**ADC Planning Consultation
Conservation/Design Officer Response**

Application Number	AB/111/17/HH
Address	77 Maltravers Street Arundel BN18 9BQ
Description	First floor side extension. This application affects the character & appearance of the Arundel Conservation Area
Case Officer	Mr D Easton
Date	31.10.17

PROPOSED FLOOR PLANS
DATE: July 2017
SCALE: 1:100 @ A3
JOB No: 1012
DRWG No: 105 Rev.

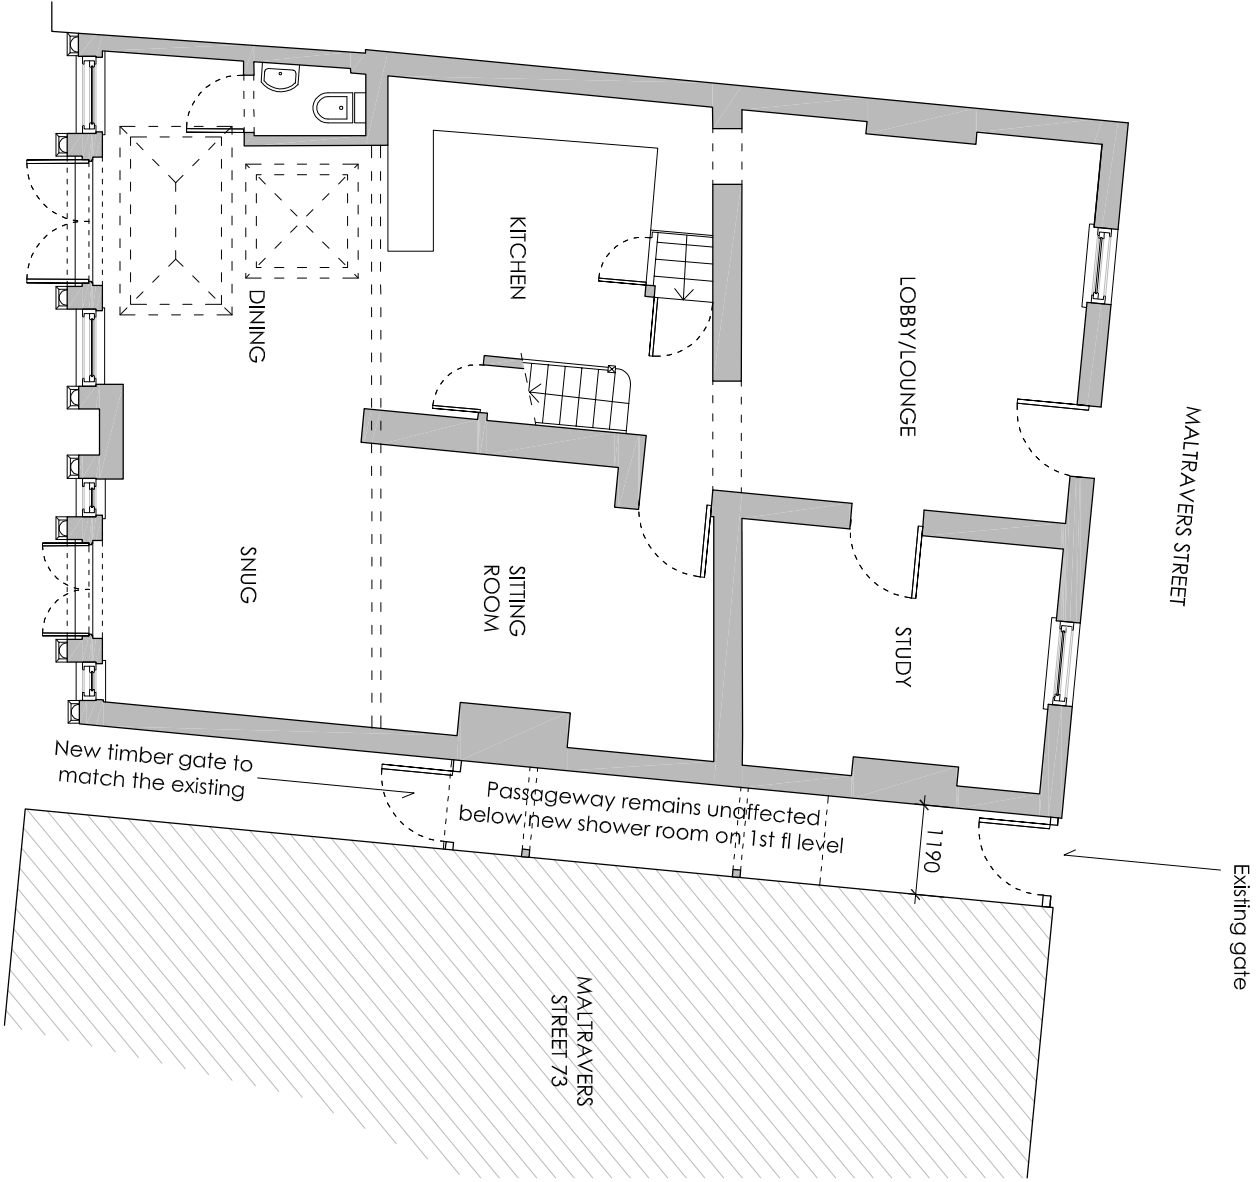
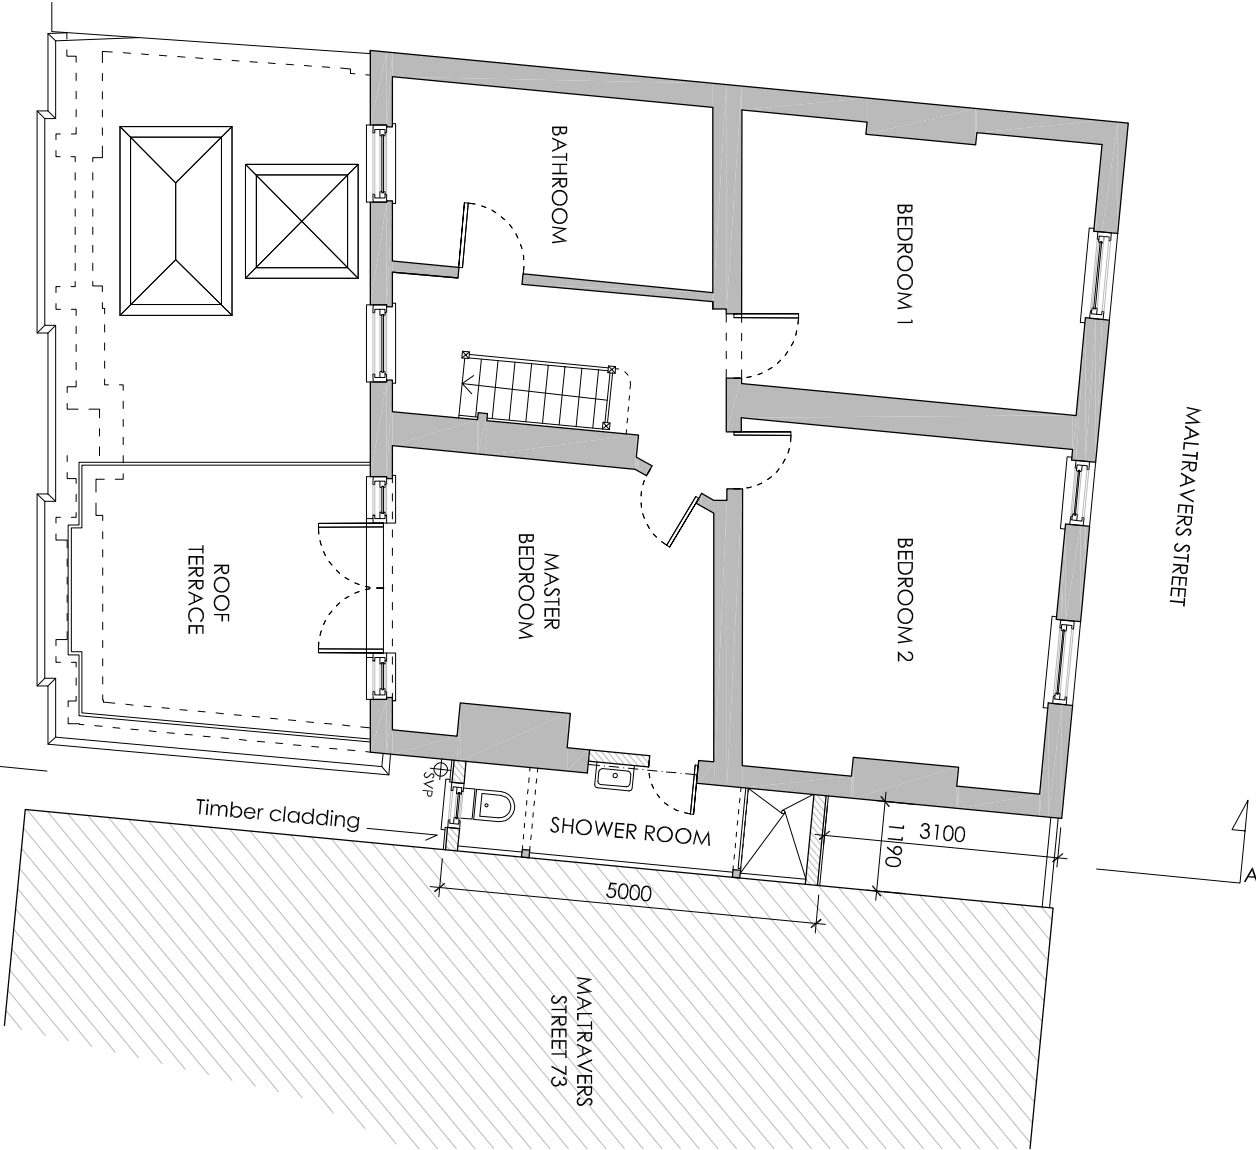
The application aims to achieve an additional bathroom to first floor. The proposal within the plot is set back from the street frontage/building plane of the terrace. The new structure would be supported via steel supports in the existing alleyway between two private residences. There are several instances in Arundel of the small alley between houses being infilled or built over as is proposed in this instance.

The building is Grade II listed. To achieve the room, a section of the west elevation would be removed. While this loss is regrettable, it is considered justified to achieve the proposed scheme.

PROPOSED NORTH & SOUTH ELEVATIONS,
STREET VIEW & SECTION AA

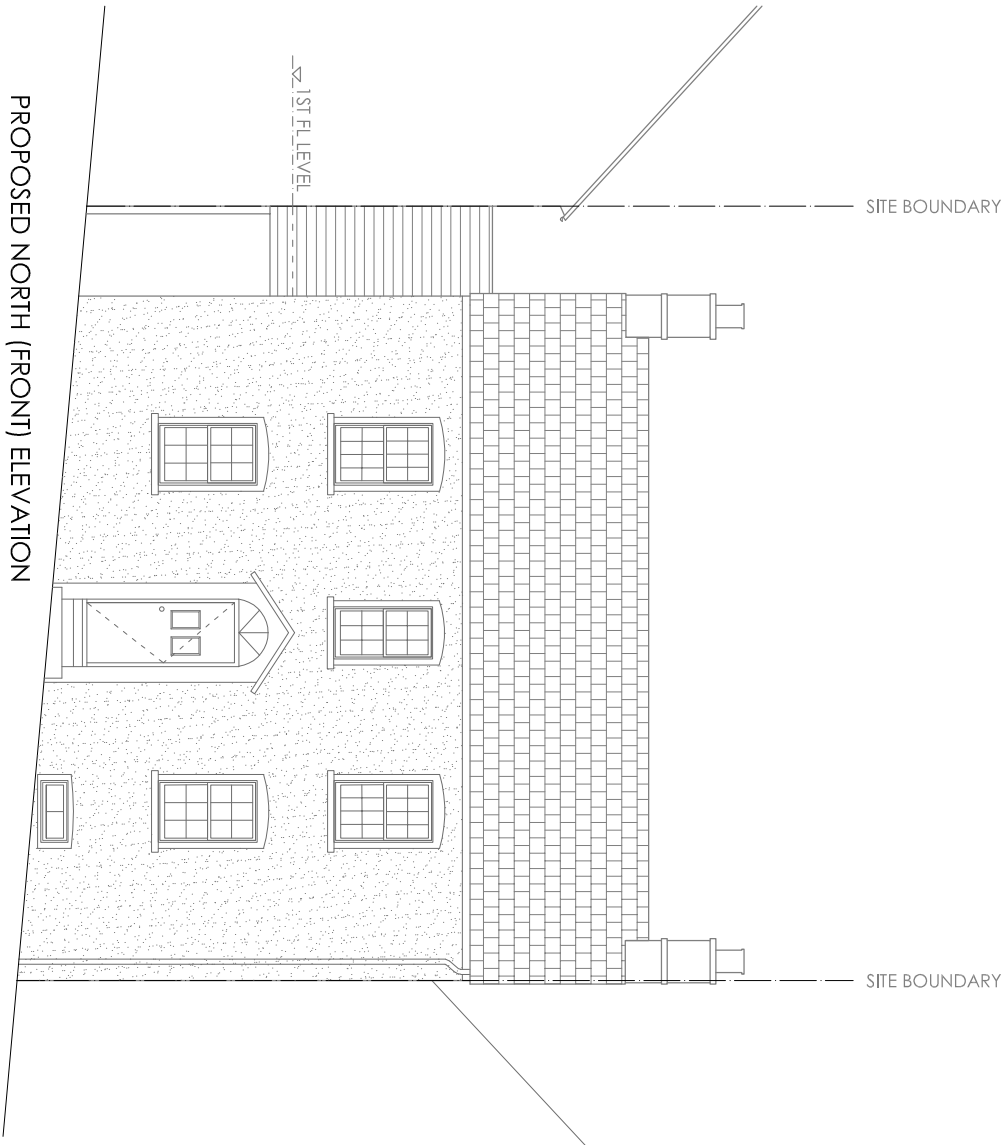
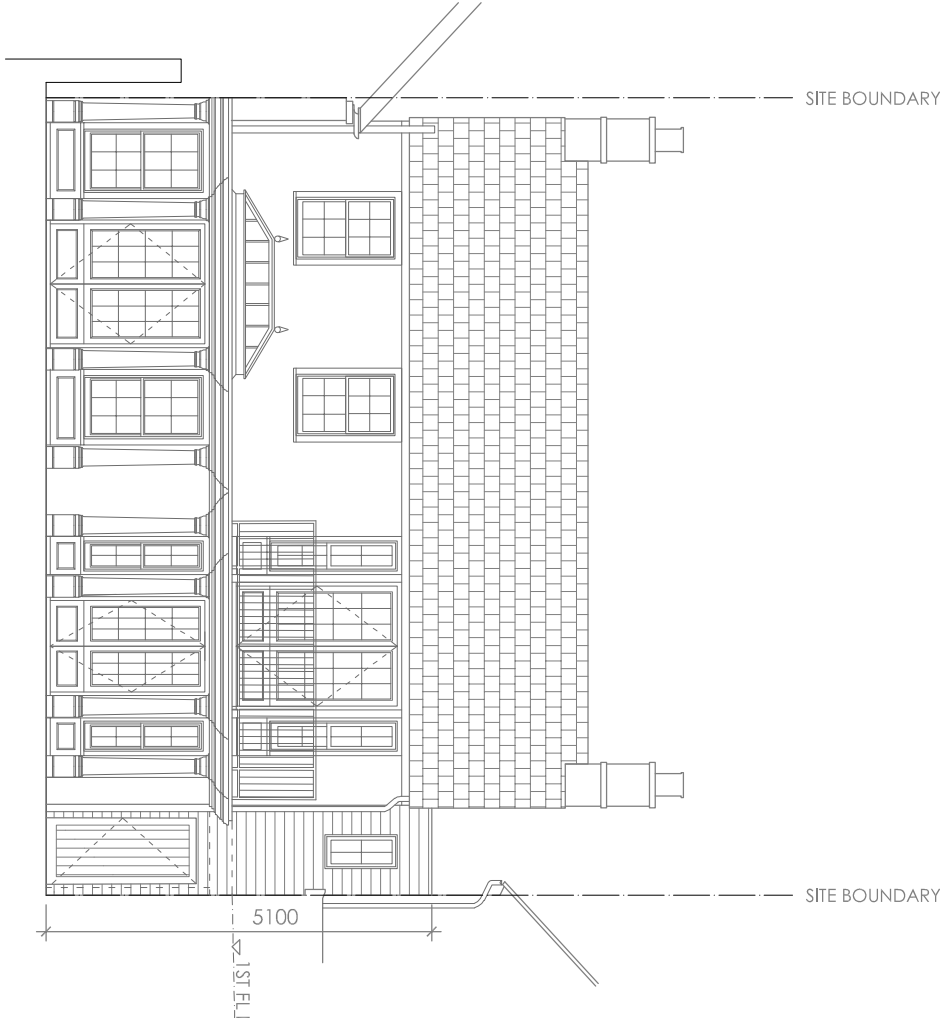
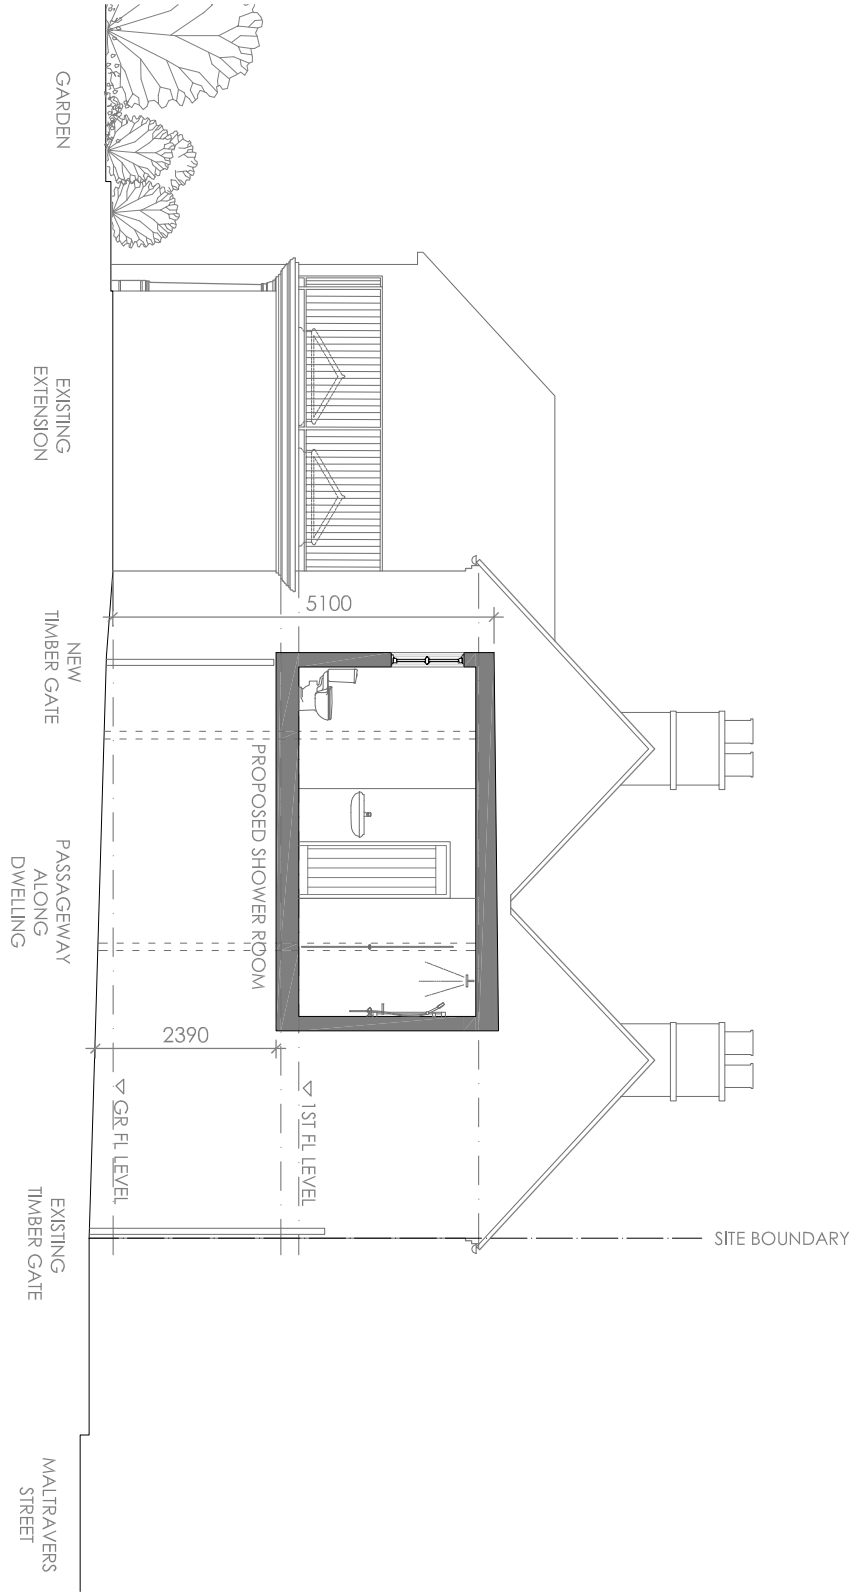
The proposal itself, and its supporting structure would be invisible from the public realm as it is located well behind an existing gate. Thus, it is considered that the proposal is non-intrusive and does not adversely affect the Conservation Area, or the setting of a listed building.

It is noted that in pre-application discussions with the Dr Whightman, that it was recommended that the existing gate/door opening be repainted to eggshell in white or a darker tone.
